Consultation Response from KC, Highways Development Management (HDM)**Application Ref. 2024/92365 - Land at Blackmoorfoot Road/Felks Stile Road, Crosland Moor, Huddersfield, HD4 7AD**

(amended details) Reserved Matters application (including the considerations of appearance, scale, layout, access (including pedestrian and cycle access into and within the site and vehicular access within the site), and landscaping) for the erection of 469 residential dwellings and associated works including landscaping and the provision of open space, pursuant to [EASTERN PARCEL of] permission 2024/92614 for variation and removal of conditions 4 (access works), 8 (Blackmoorfoot Road improvements), 10 (junction details), 16 (retaining wall design), 17 (highway structure design), 18 (surface water drainage strategy), 37 (external lighting strategy) and 39 (crime mitigation measures) of previous outline permission 2020/92546 (with details of points of access only) for the development of up to 770 residential dwellings (Use Class C3), including up to 70 care apartments (Use Classes C2/C3) with doctors surgery of up to 350 sqm (Use Class D1); up to 500 sqm of Use Class A1/A2/A3/A4/A5/D1 floorspace (dual

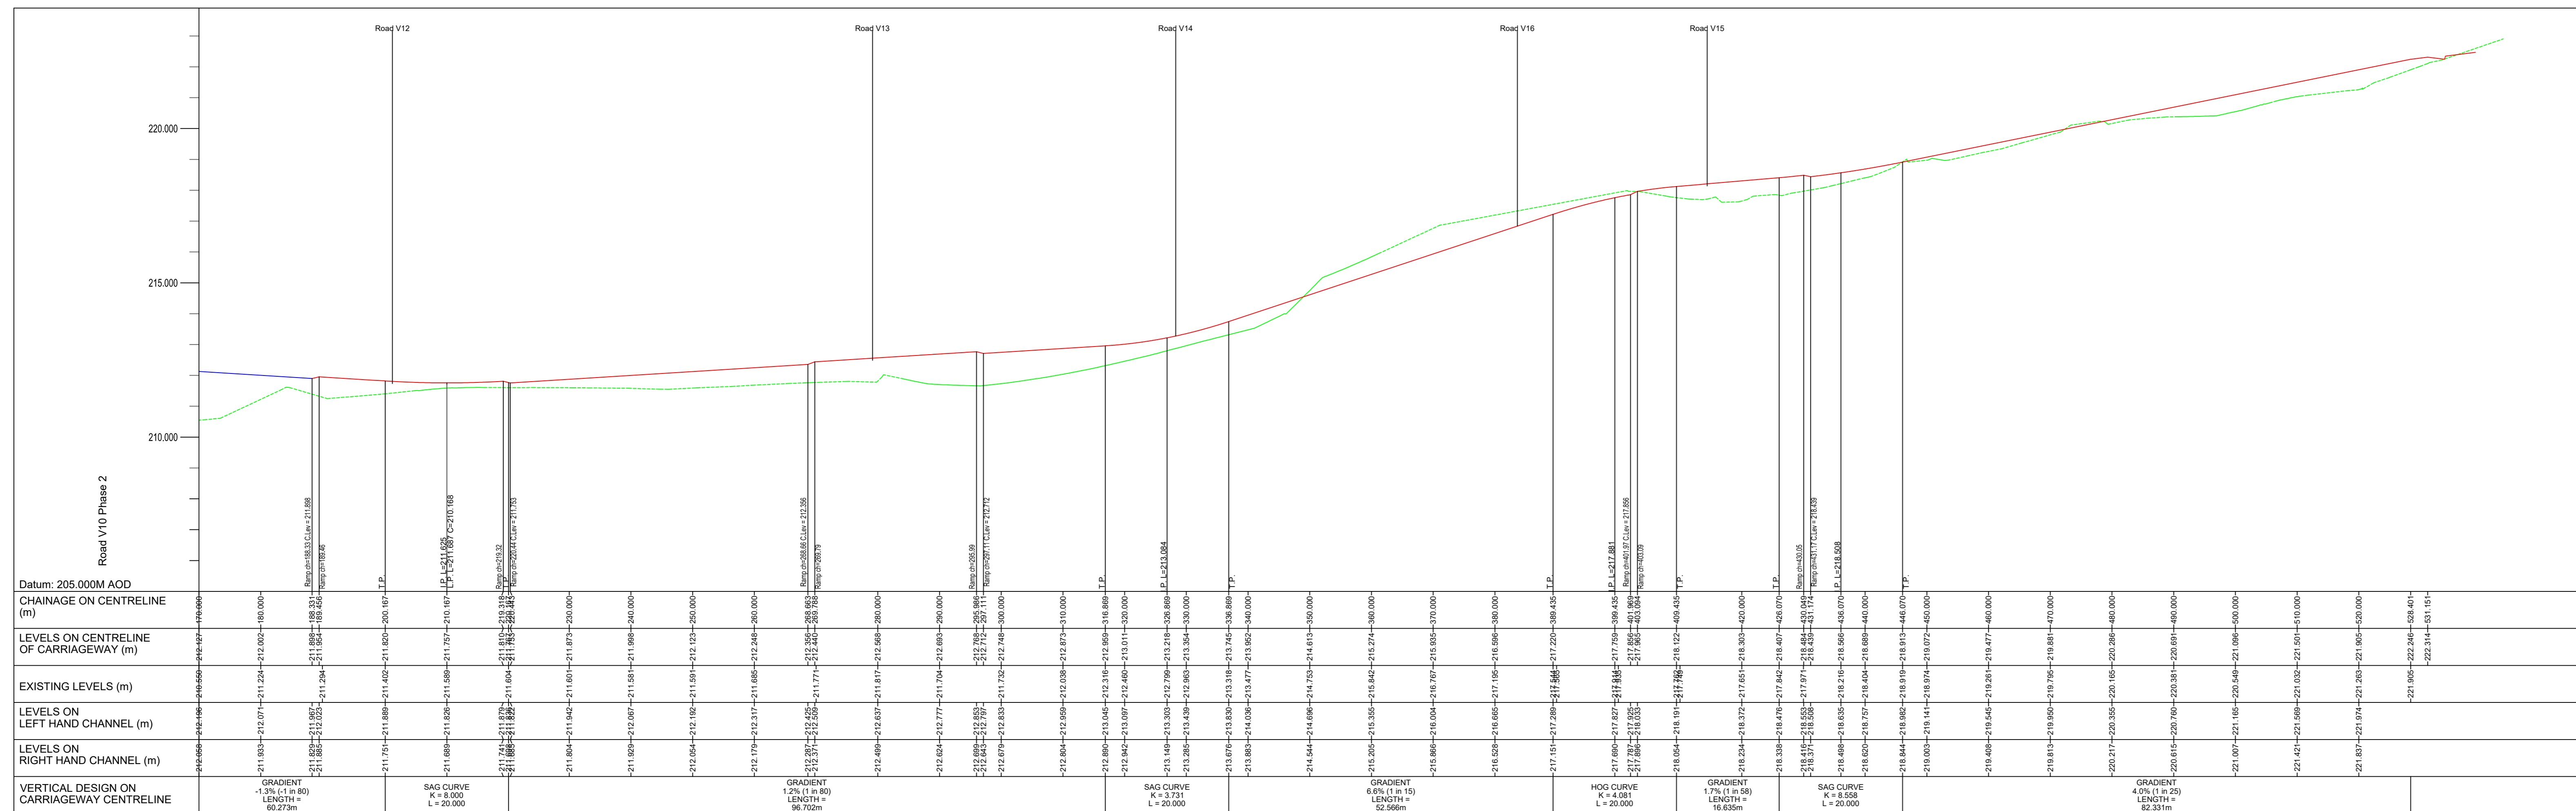
Indicative long section information has also been provided for all streets, which confirm that suitable gradients for all streets (generally max. 1:15, or max. 1:20 on shared surface streets) and paths are achievable. This includes suitable vertical alignments at the tie-in points on the streets that join the adjacent (western) RM site along Roads M1/V1, M2/V2 and V6, as demonstrated on the combined indicative long section drawings provided. That said, some of the indicative vertical alignment information provided for some streets is not in full accordance with the Councils Highway Design Guide SPD (e.g. vertical curves below minimum length requirements). Therefore, the vertical alignment of the streets and paths will need to be developed further as the detailed design progresses.

However, it is recommended that a new Condition is imposed that requires that the tie-in levels at Roads M1/V1, M2/V2 and V6, which link the two RM residential sites, to be in accordance with the indicative combined long-sections drawings provided. This should be in accordance with Condition 2 that has already been applied to the adjacent residential RM site (2024/92235). This condition has been written to allow flexibility, as this will be necessary to take into account the design development of the S38 works packages, with any changes subject to agreement of revised tie-in levels between all interested parties (e.g. between the separate RM developers and the Highway/Planning Authority).
